Rezoning Transportation Analysis

Petition Number: 2023-011

General Location Identifier: 04521224, 04521223

Date	Description
5-24-23	First Review (TM)
6-21-23	Second Review (DR)
7-28-23	Third Review (ME)
9-26-23	Fourth Review (IW)

TITLE  
PRELIMINARY SITE PLAN  
R-8 (CD)  
RZP\_2023\_011

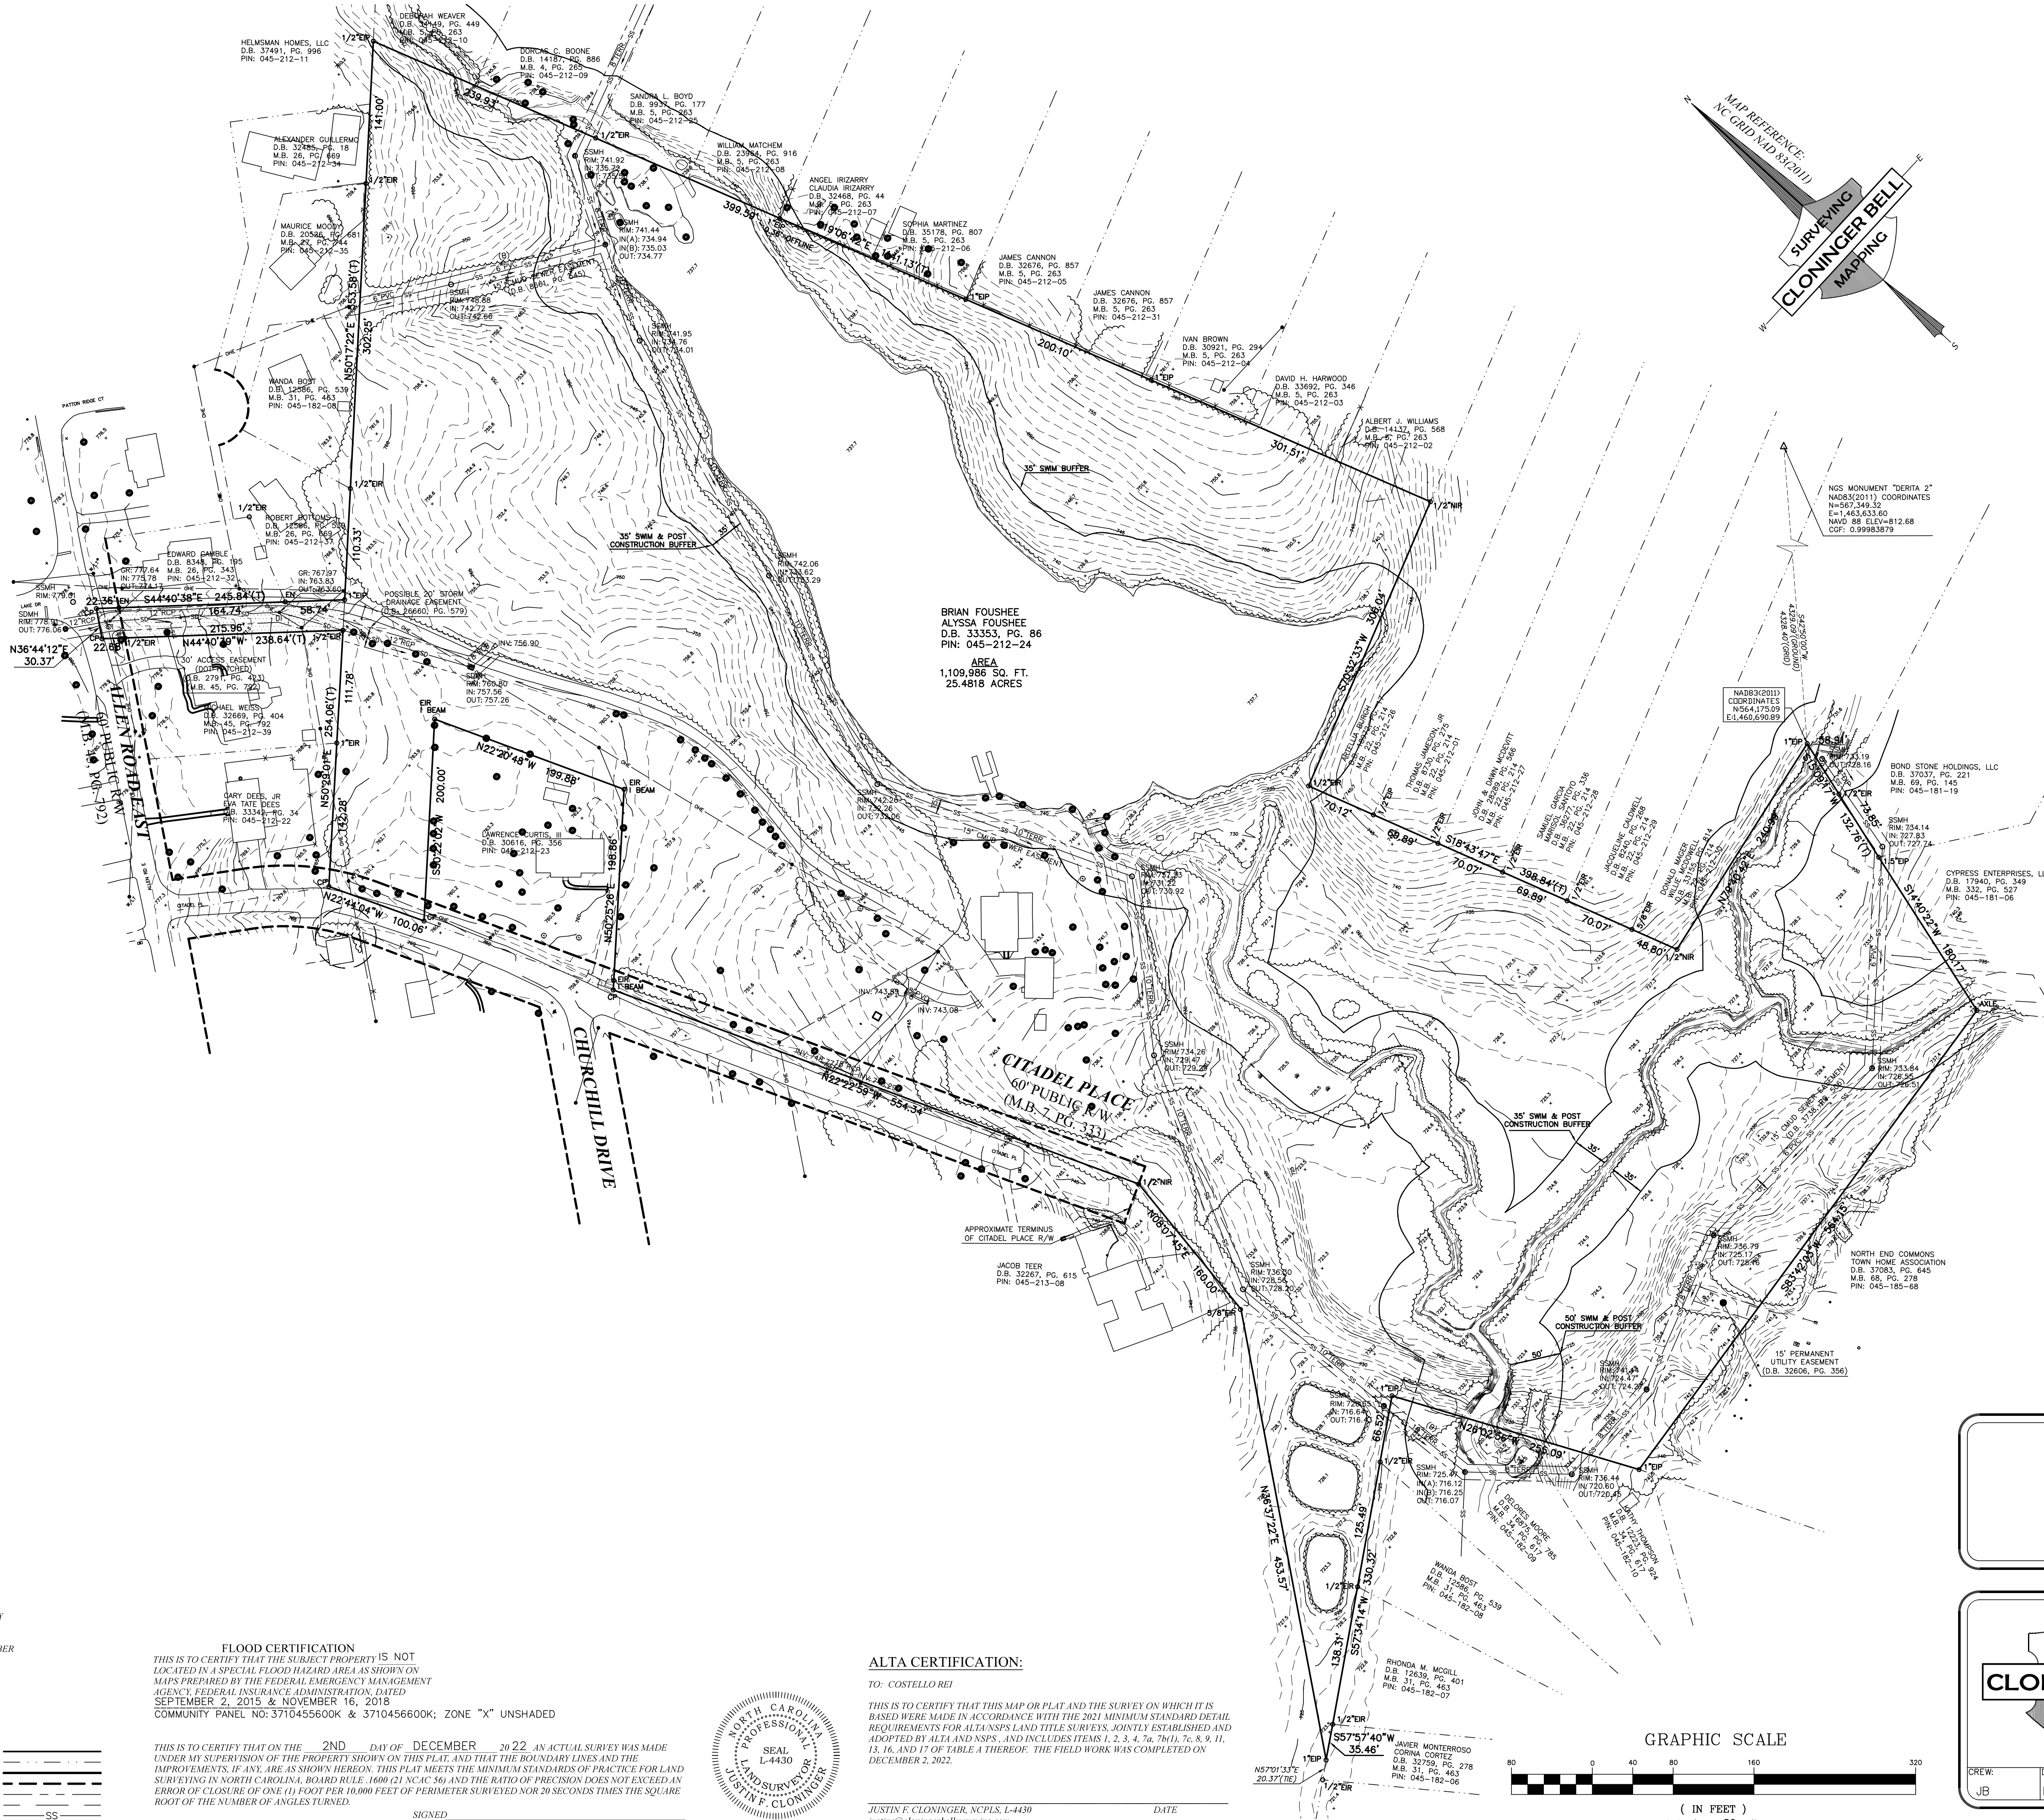
- ~~a. **Citadel Place:** Location of curb and gutter to be moved to 13-foot from roadway centerline to accommodate the Charlotte Streets Map with a roadway typical section of Local Residential medium.~~

~~Label and dimension the curb and gutter from the centerline for each road on the site plan.~~

~~3. **Revise site plan and conditional note(s) to commit to dedicate 30-foot of right-of-way from the road centerline. The site plan shall label and dimension the right-of-way from the road centerline.**~~

~~**Clarifying comment 6.21.2023:** Add conditional note to commit to dedicate 30-foot of ROW from the road centerline of Citadel Place. Additionally label and dimension.~~

~~4. **Revise site plan and conditional note(s) to commit to construct an 8-foot planting strip, and 6-foot sidewalk on all internal roadways Chapter 19. The site plan shall label and dimension both items from the back of curb and gutter or edge of pavement.**~~

~~**Clarifying comment 6.21.2023:** Add conditional note to construct 8-foot planting strip and 6-foot sidewalk on all internal roadways.~~

- ~~7. Revise site plan and conditional note(s) to commit to revising the proposed hammerhead to a cul de sac as to not stub to the single-family homes to the North of the petition.~~
